**Alesco Senior College, Argenton (SSD-9683)
Notice of Exhibition**

Objective reference: CD19/05140

Attachment A – Comments on SSD 9683

Site Plan

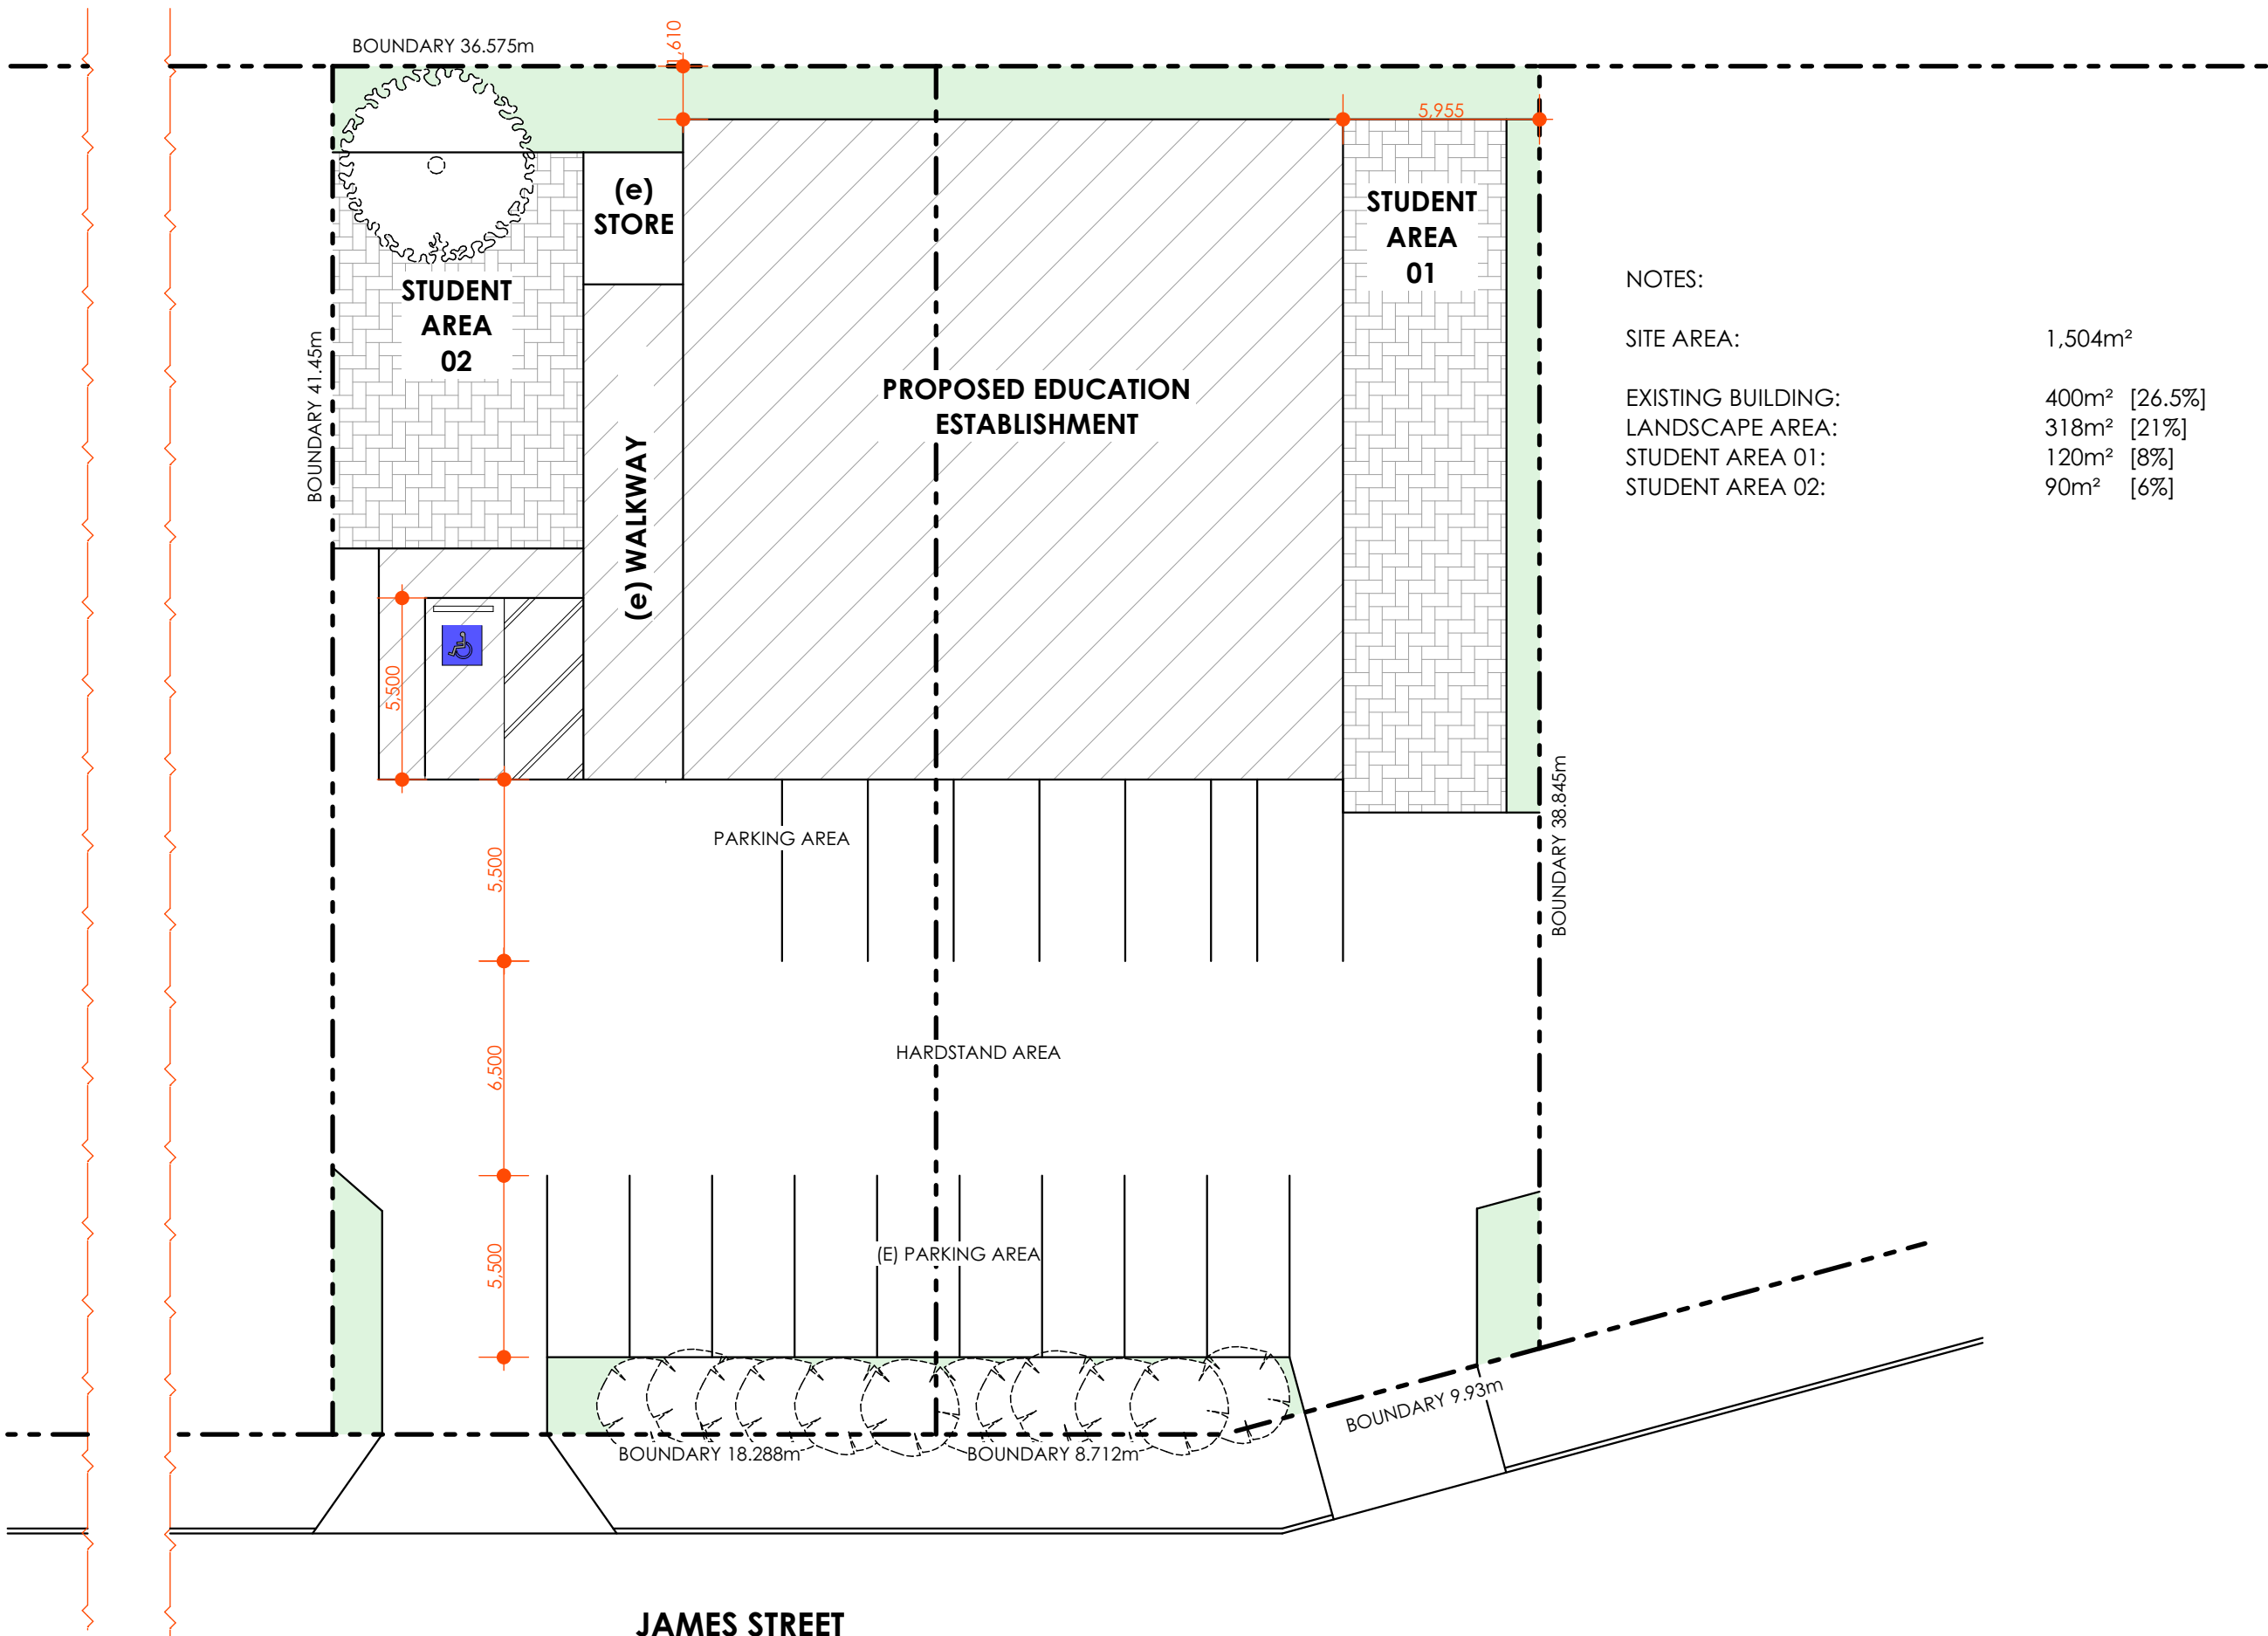
As the Applicant has not consulted with Sydney Trains, the EIS has not considered the impact on the rail corridor access gate used by Sydney Trains, located on the corner of James Street and Victoria Street. The access gates are used for maintenance and emergency purposes, and therefore gate access must remain clear for large vehicles at all times.

- During construction and operation of the development, the Applicant shall maintain clear access to the rail corridor at the existing access gates on James Street. Any Construction Traffic Management Plan or Operational Traffic Management Plan shall identify the need to maintain clear access to the rail corridor gates and include provisions to direct construction personnel, staff, parents or students to maintain clear access. Clear access involves ongoing access (at all times) by rail vehicles, plant and equipment to support maintenance and emergency activities.
